CITY OF ALBUQUERQUE

July 29, 2022

**Re: Rosa Parks Stockpile Yard at The Cliffs on Paseo
Erosion and Sediment Control Plan
Engineer's Stamp Date 7/28/2022 (C11E004_G)**

ESC-1

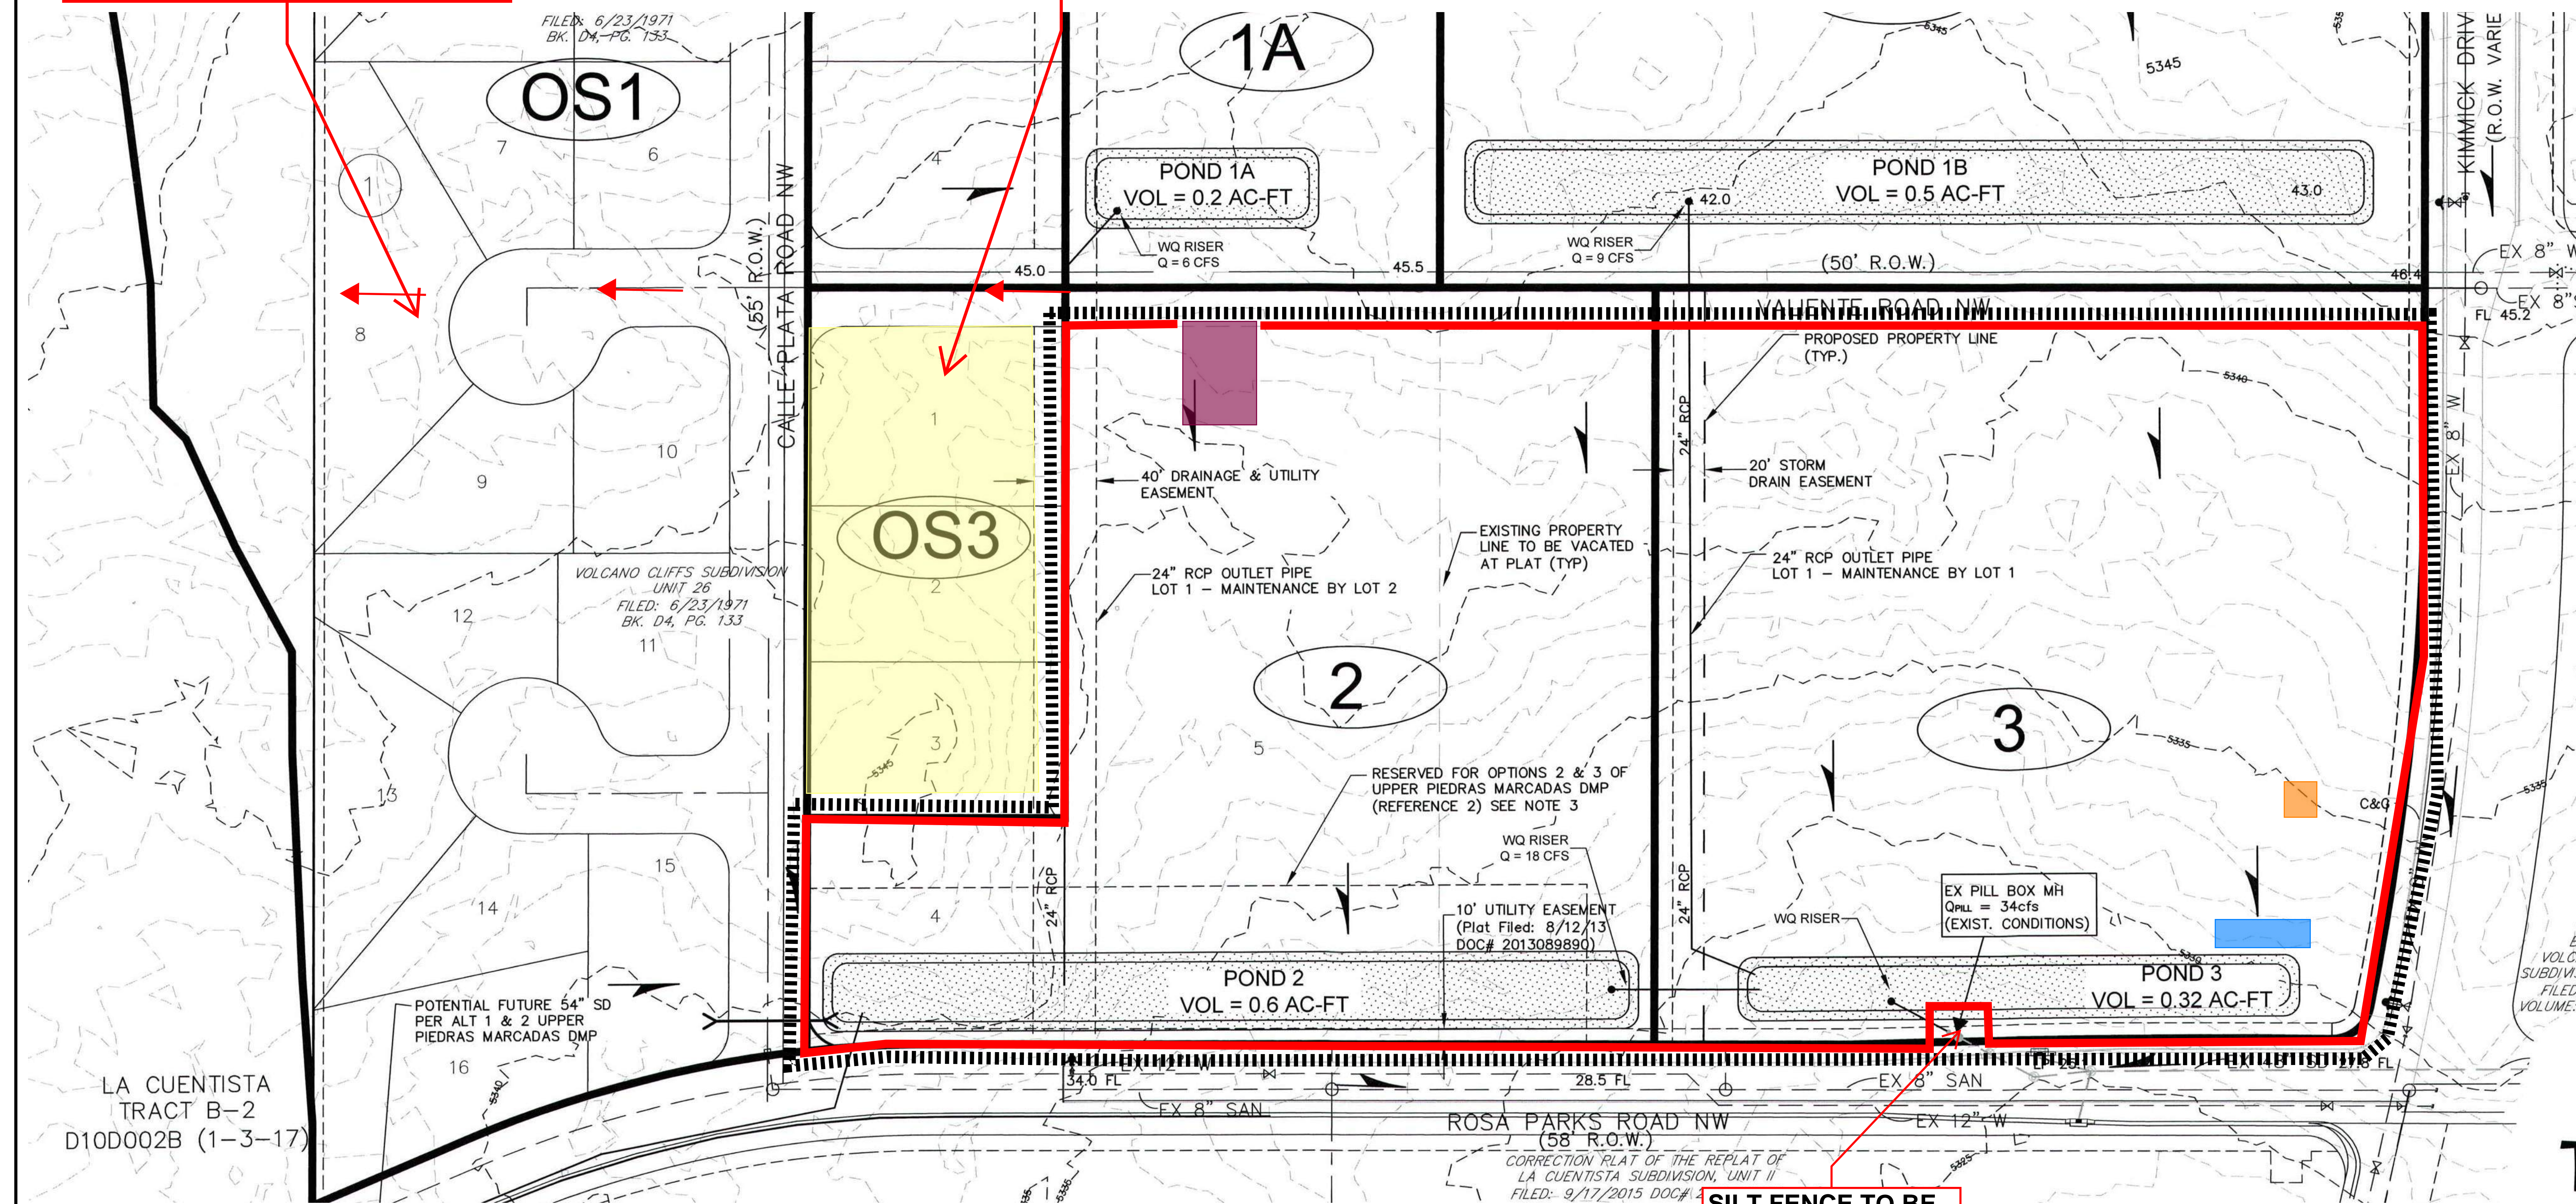
2. This site drains to an onsite inlet. Show the inlet on the plan and identify BMPs to prevent sediment from entering it. See the approved Conceptual G&D Plan for this site in drainage file C11D004. Identify locations of concentrated flow paths that enter and exit the disturbed areas. Identify locations where sheet flow enters and exits the disturbed area. Show on-site drainage patterns accurately. (CGP 7.2.4.f)

4. The SWPPP must include site-specific interim and permanent stabilization per CGP 9.4.1.c.i. Provide a specification on the ESC Plan. Include aggregate mulch in the specification for the three offsite lots.
